Lot 4, SSC Subdivision, County of El Paso, State of Colorado.

SITE PLAN

PROJECT No. 18324
 JANUARY 10, 2019
 SHEET 1 OF 1

SITE PLAN

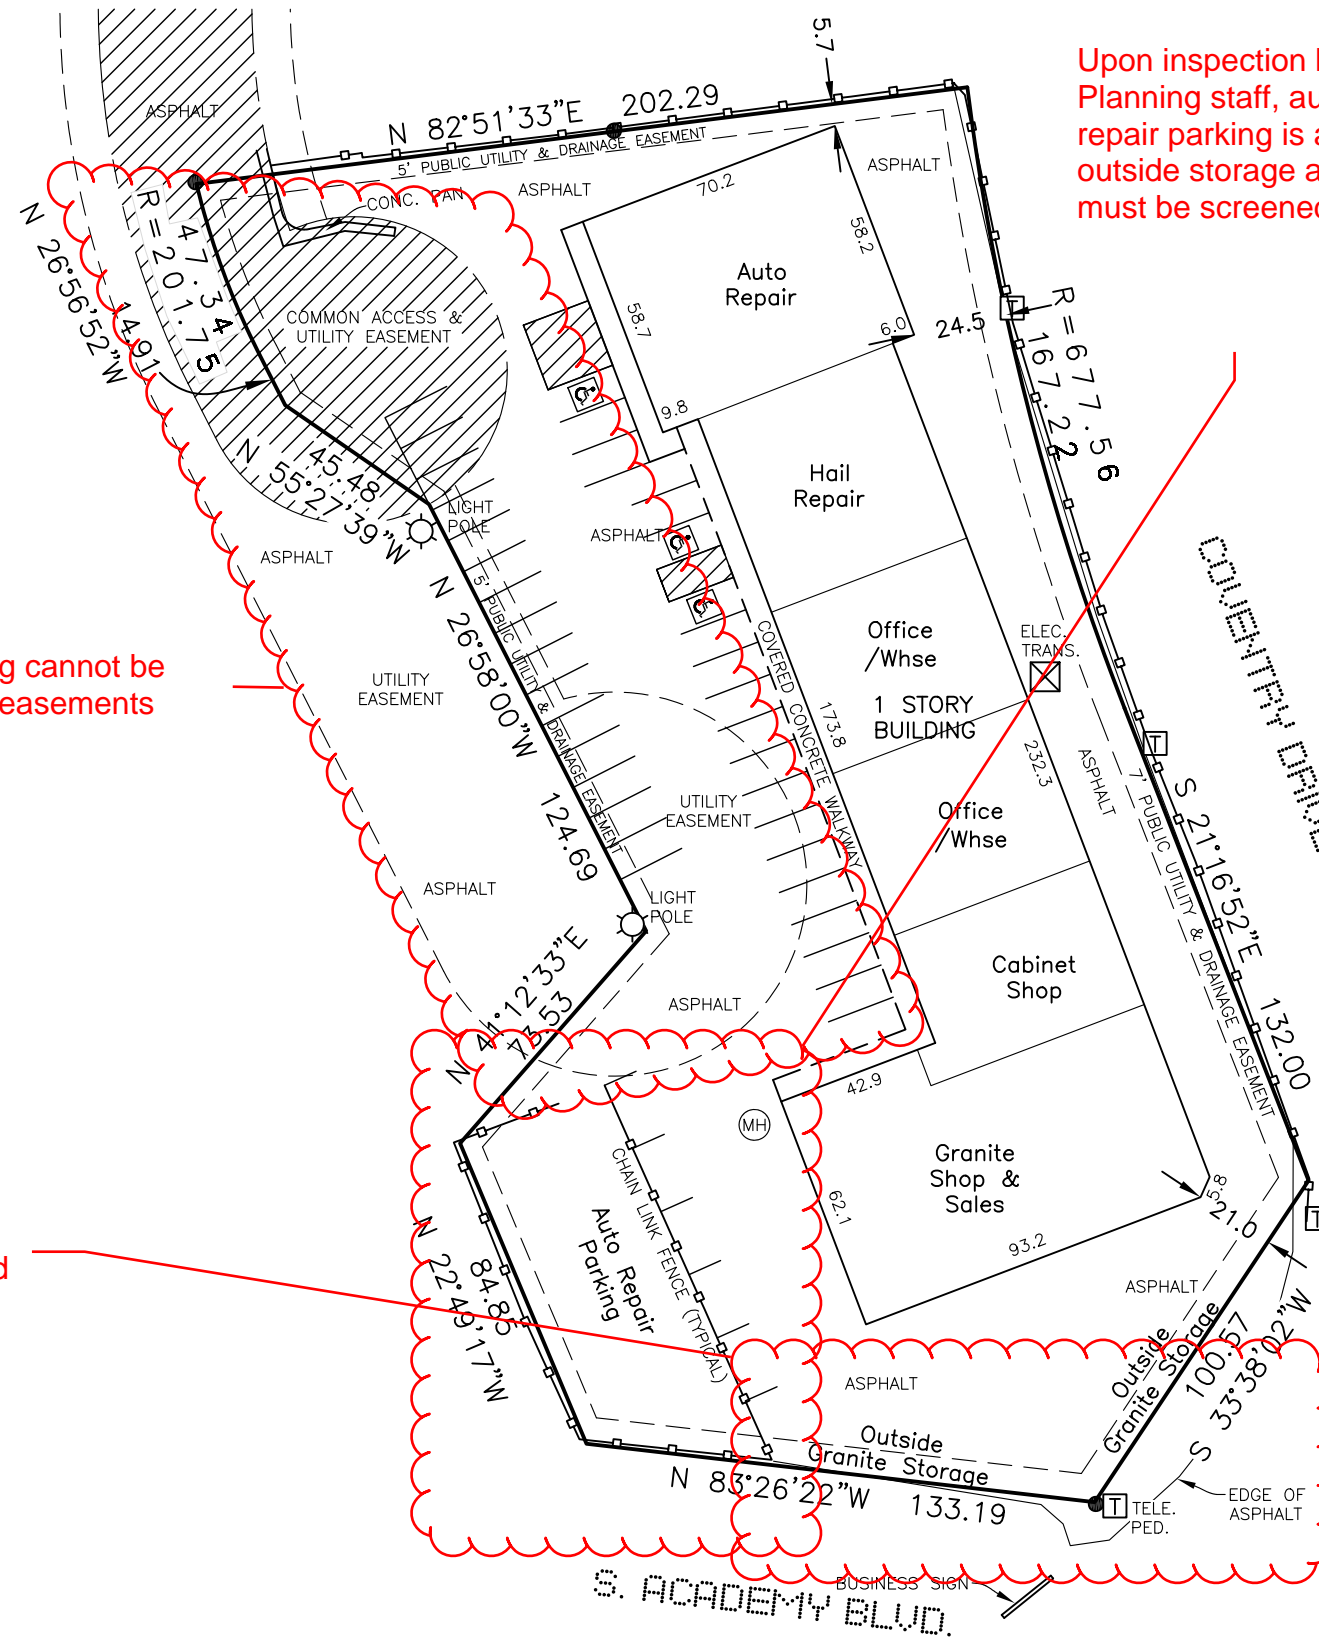
Show Parking, show and delineate the different uses located within the building.

Show where outside storage is and what it is associated with on the property.

There should be handicap accessible parking spaces depending on the total number of spaces.
